AMENDMENT RECORD SHEET - POST DECISION

Application no: H06/0428/99

Description: Erect new dwelling with
detached garage

Location: Rectory Lane
Gedney Church End
Spalding
Lincs

project / drawing		
PROPOSED NEW DWELLING FOR MR YOUNG AT CHURCHGATE & RECTORY LANE GEDNEY CHURCH END		
ELEVATIONS		
scale	date	drawn
1:100	MARCH 99	MF
project no.	drawing no	
1459	AK/2

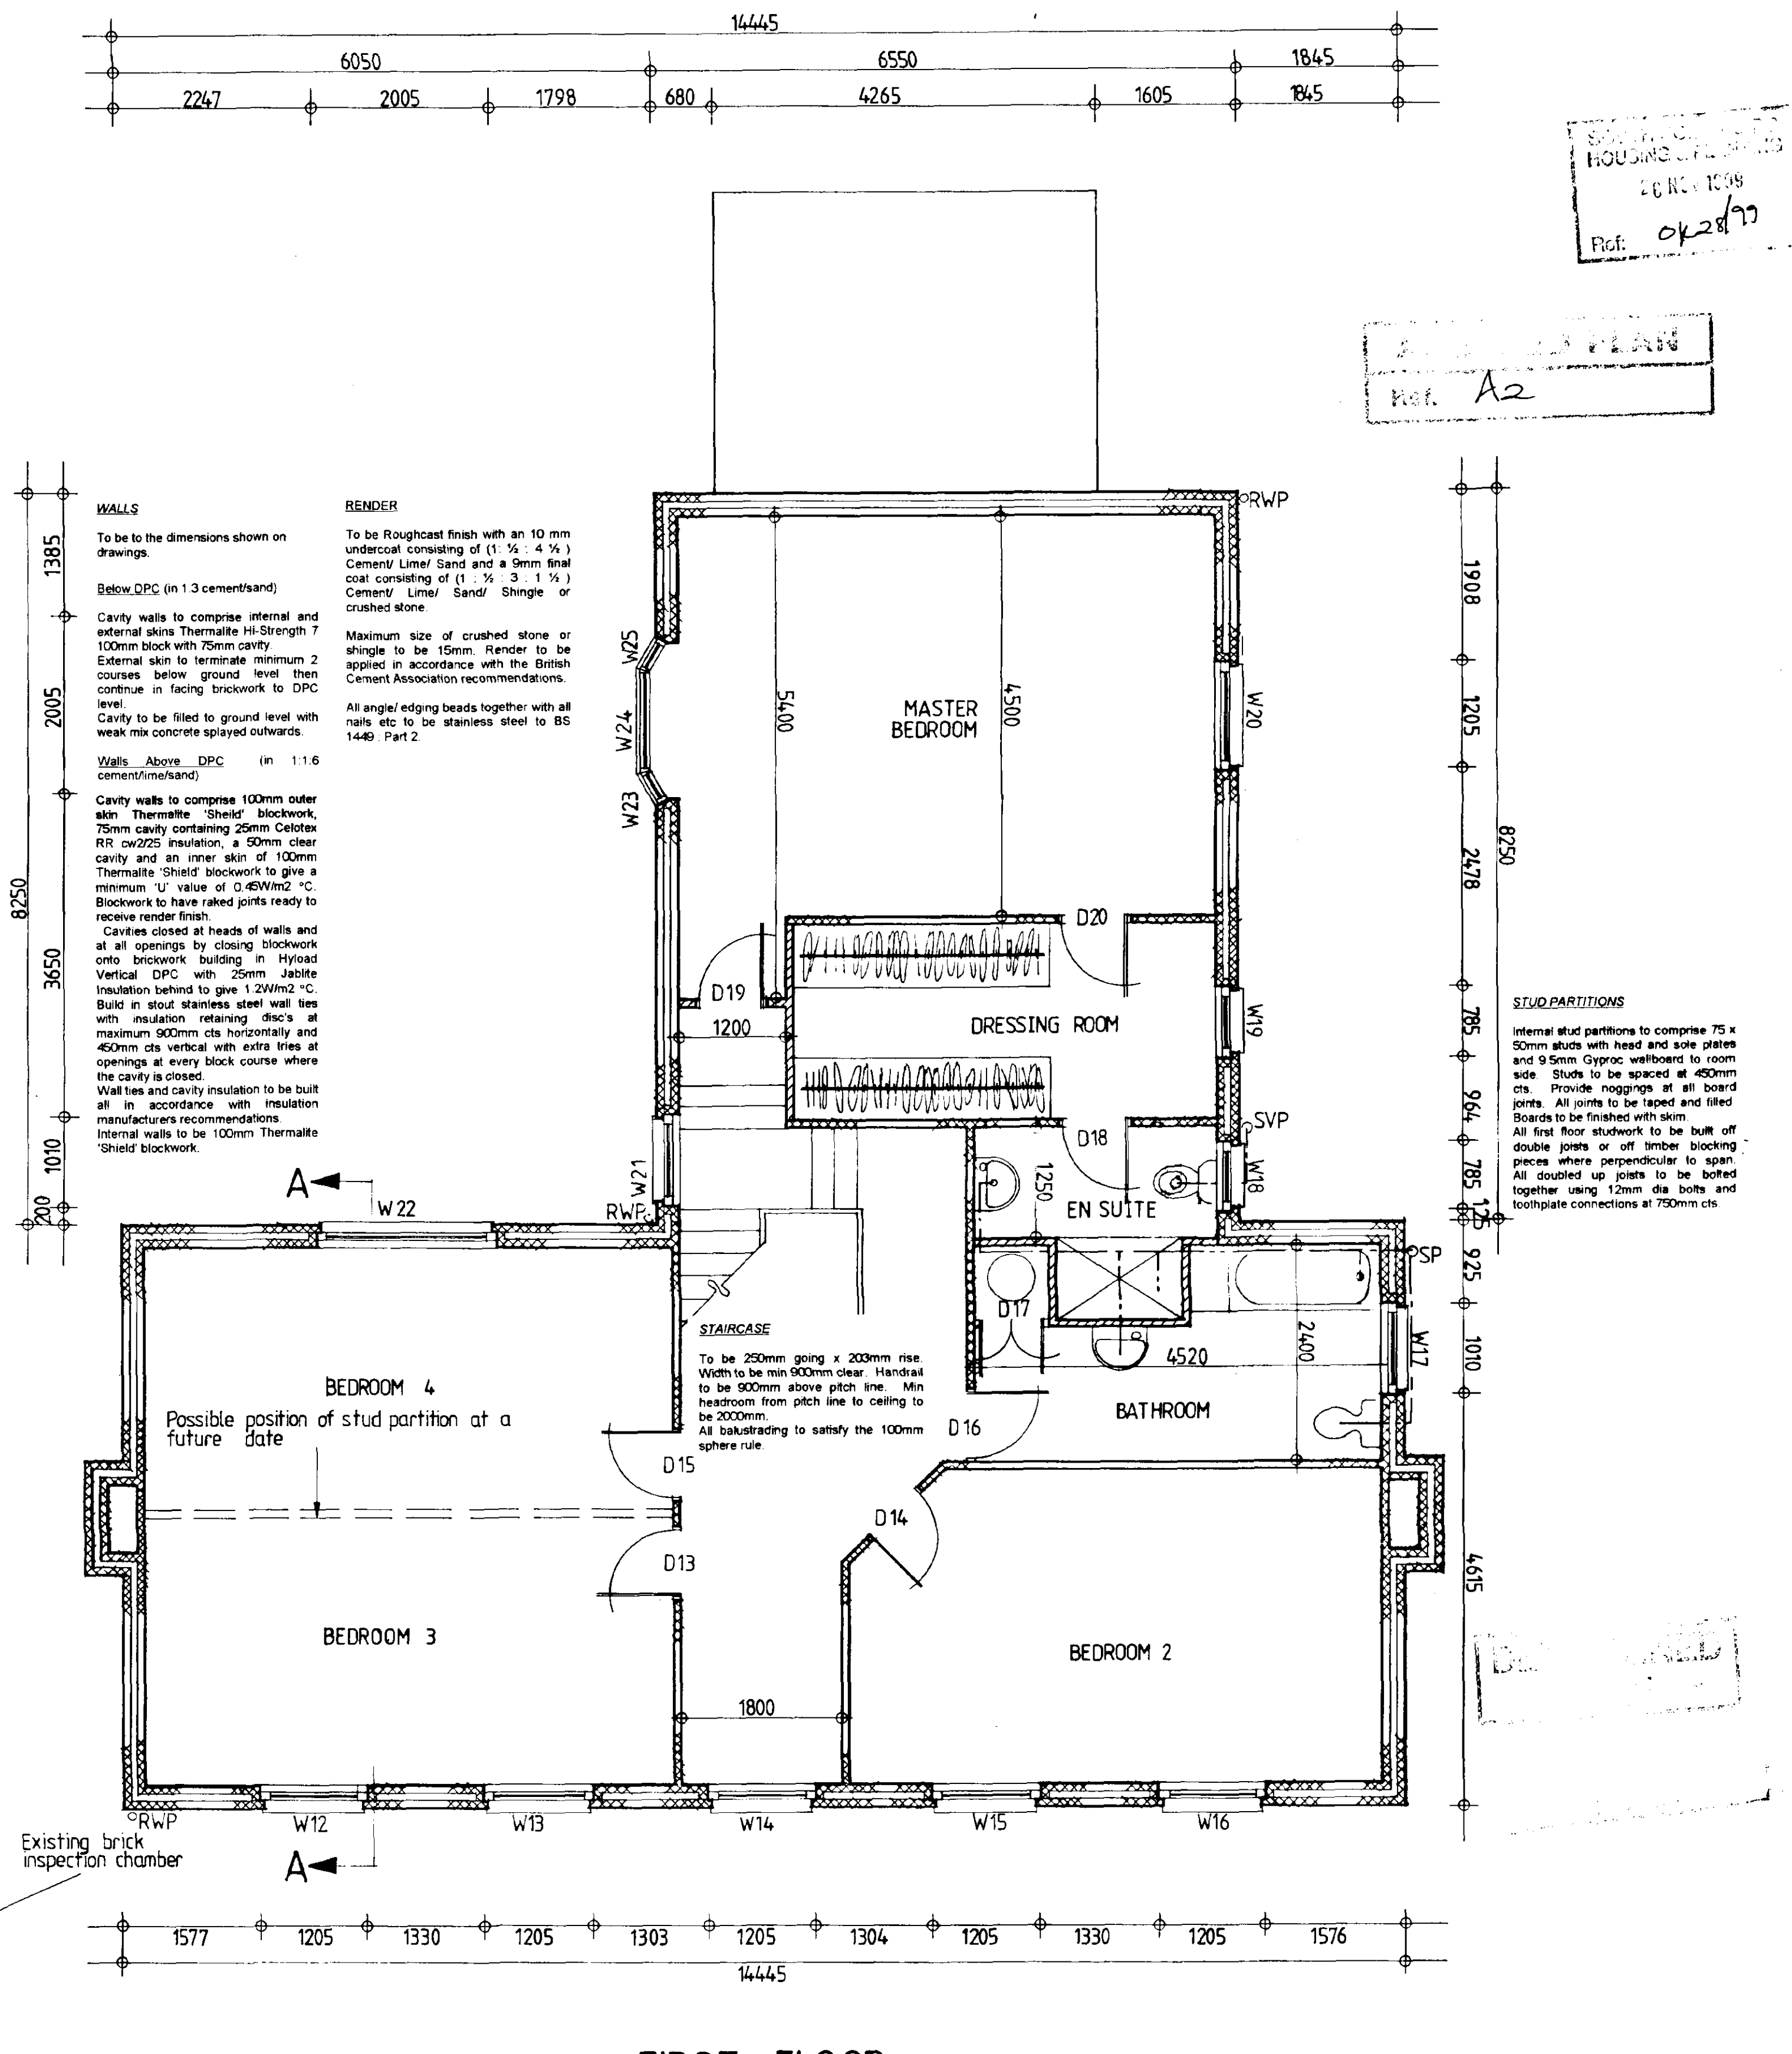
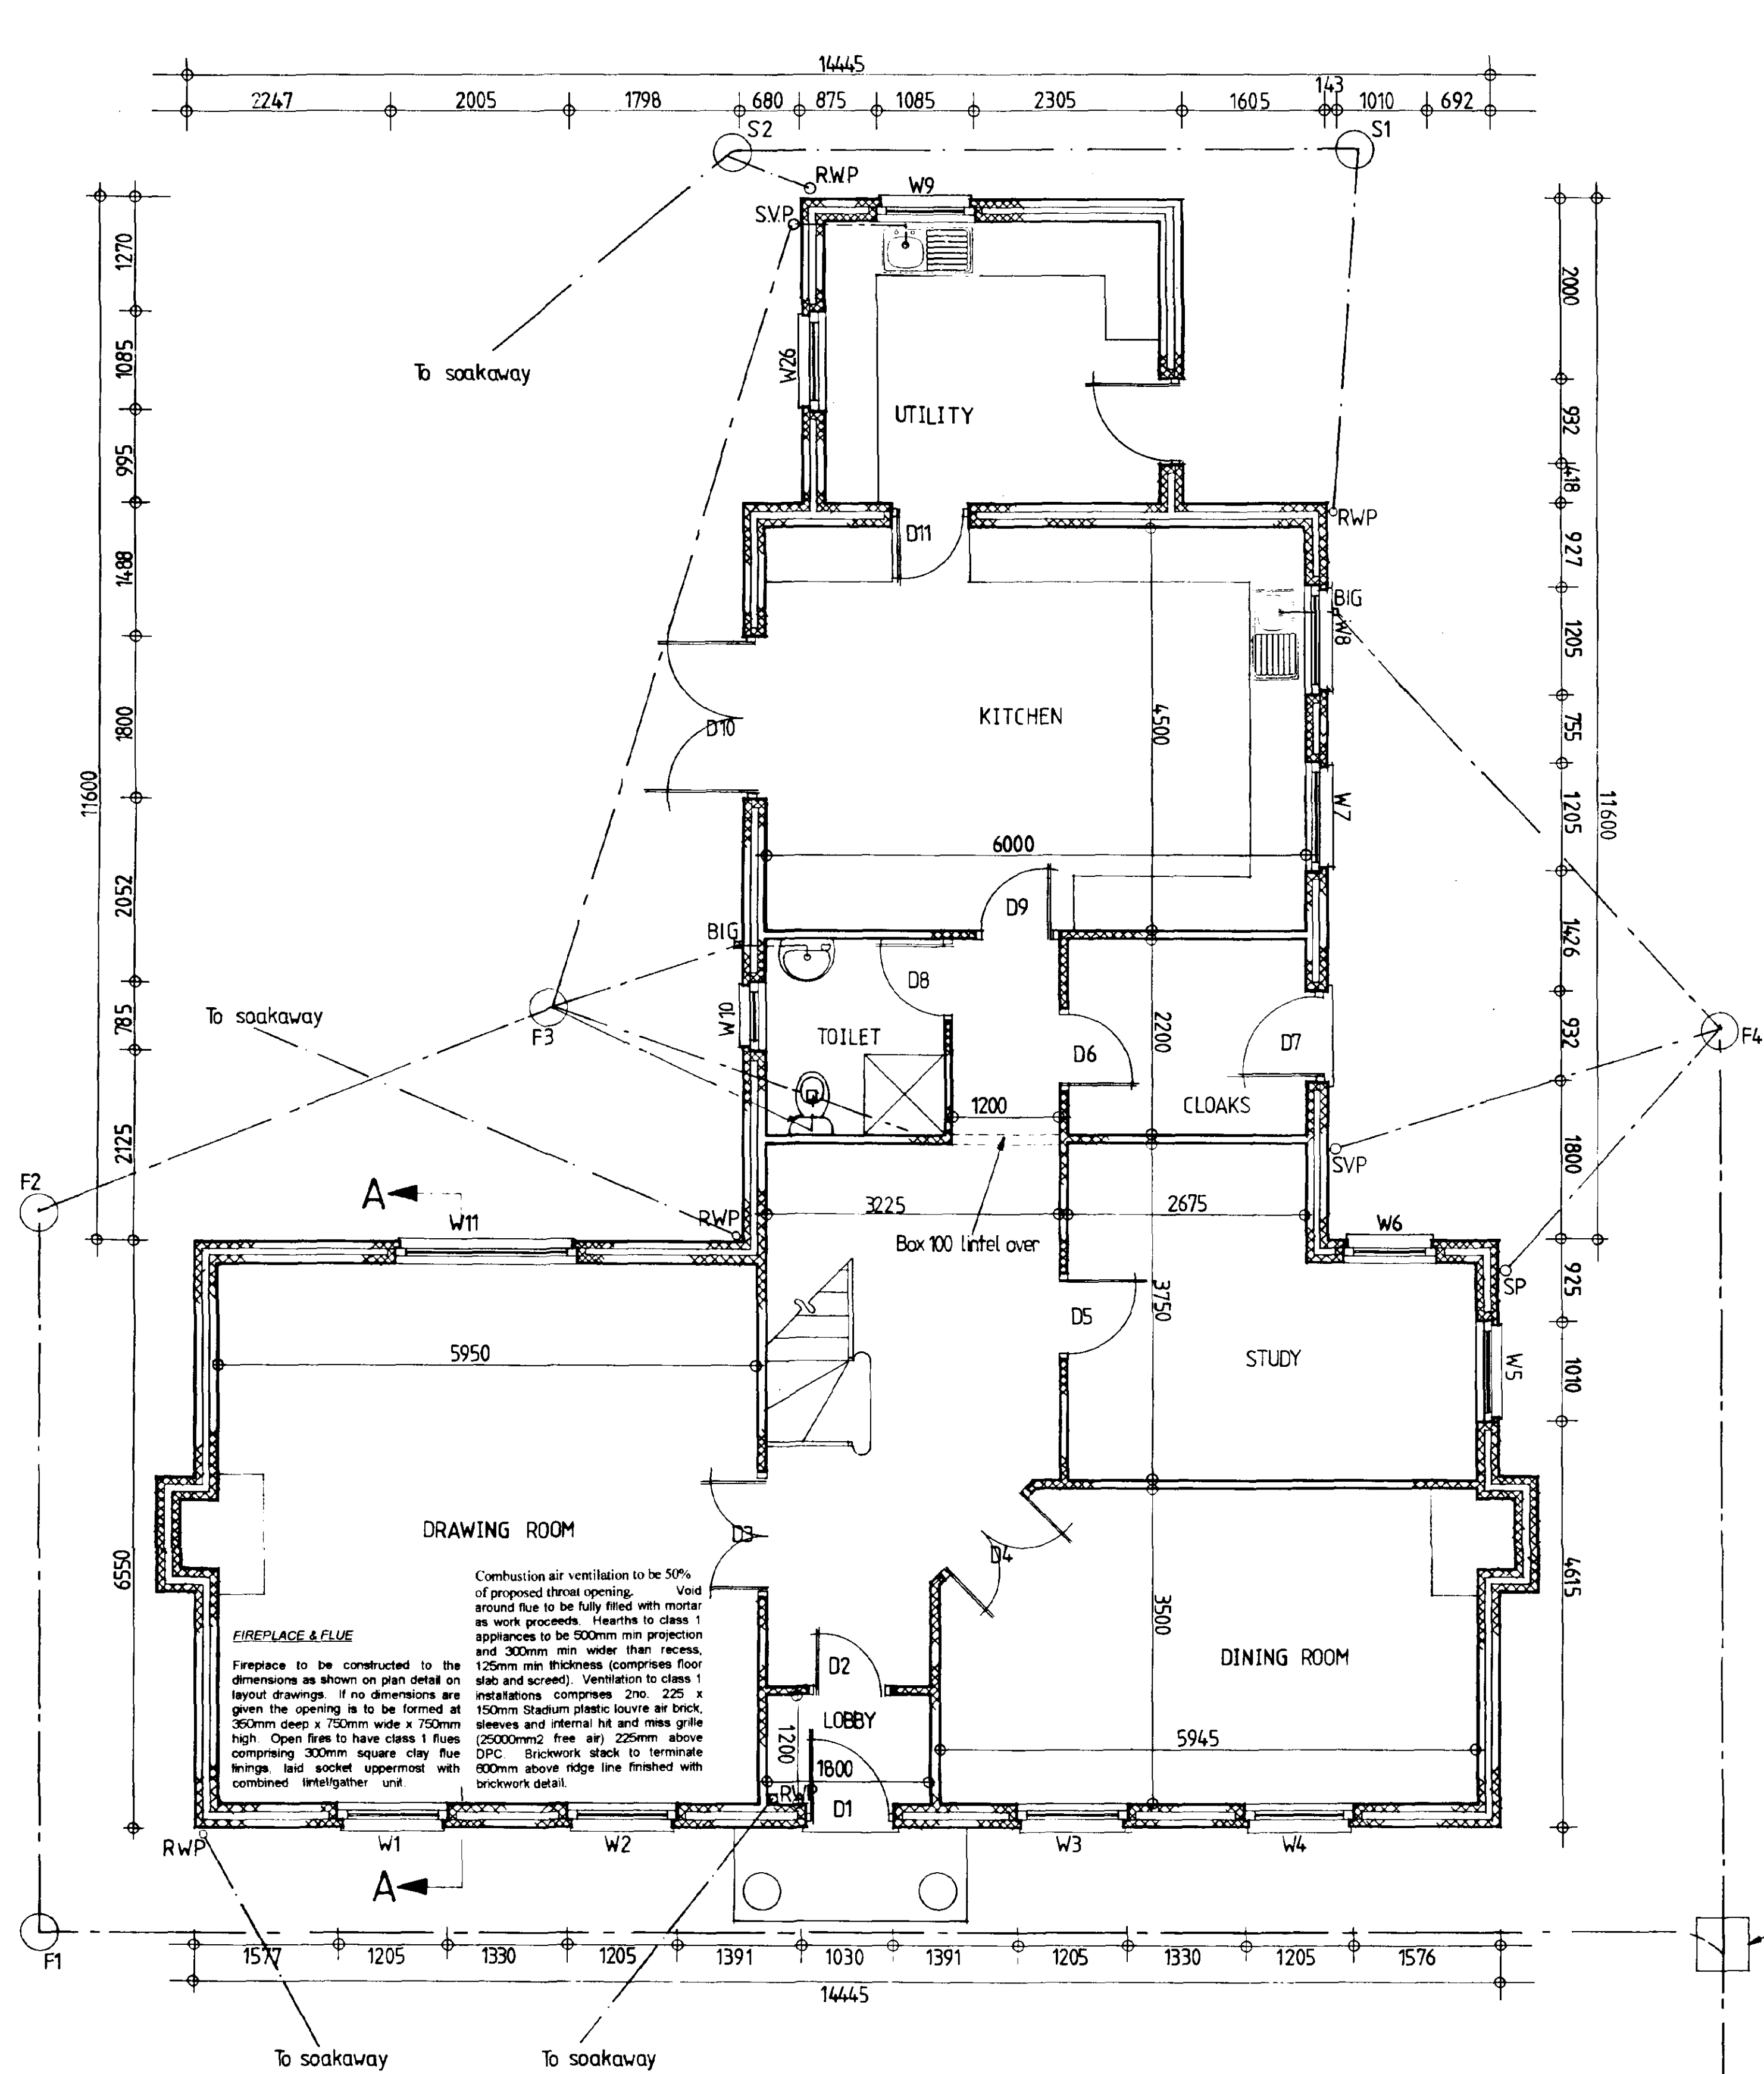
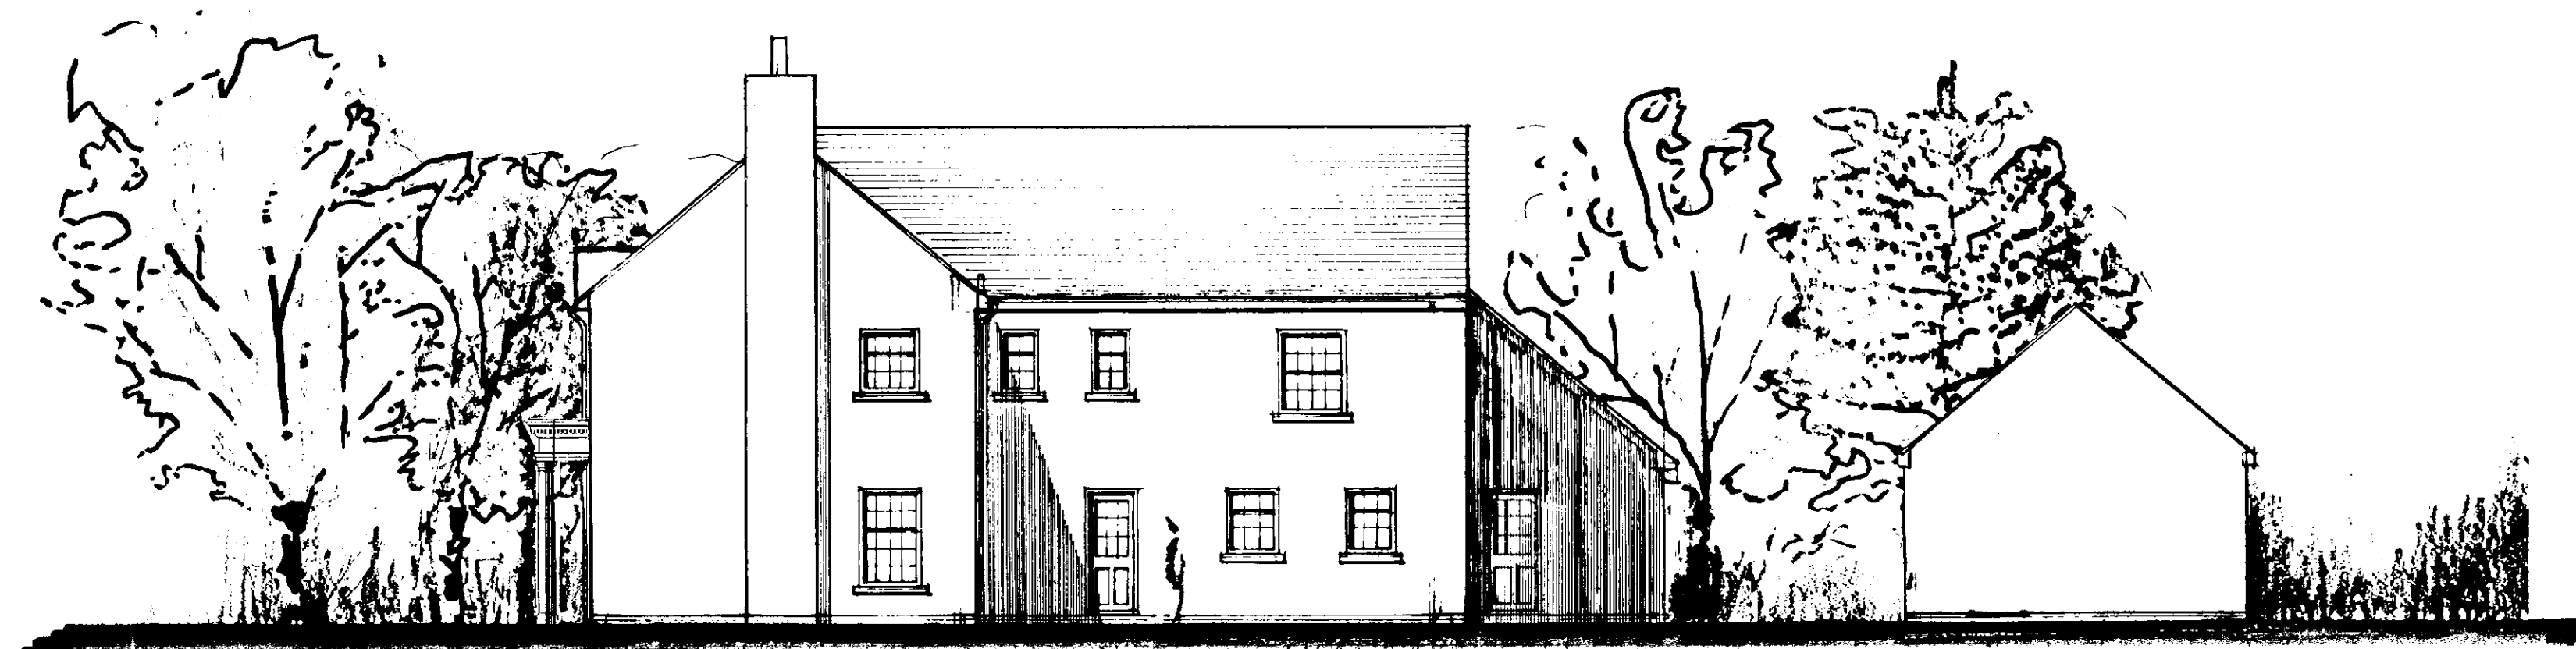
WINDOW AND DOOR SIZES REVISED
UTILITY EXTENDED
WINDOW ADDED IN UTILITY ON SOUTH ELEVATION
WIDTH OF REAR WING EXTENDED
STONE SUB SILLS ADDED
MINOR ADJUSTMENT TO SETTING OUT POSITION

Amendment: Minor alterations to exterior and siting
Dwg. No. AB/1, AB/9 and AK/2 Rev 3
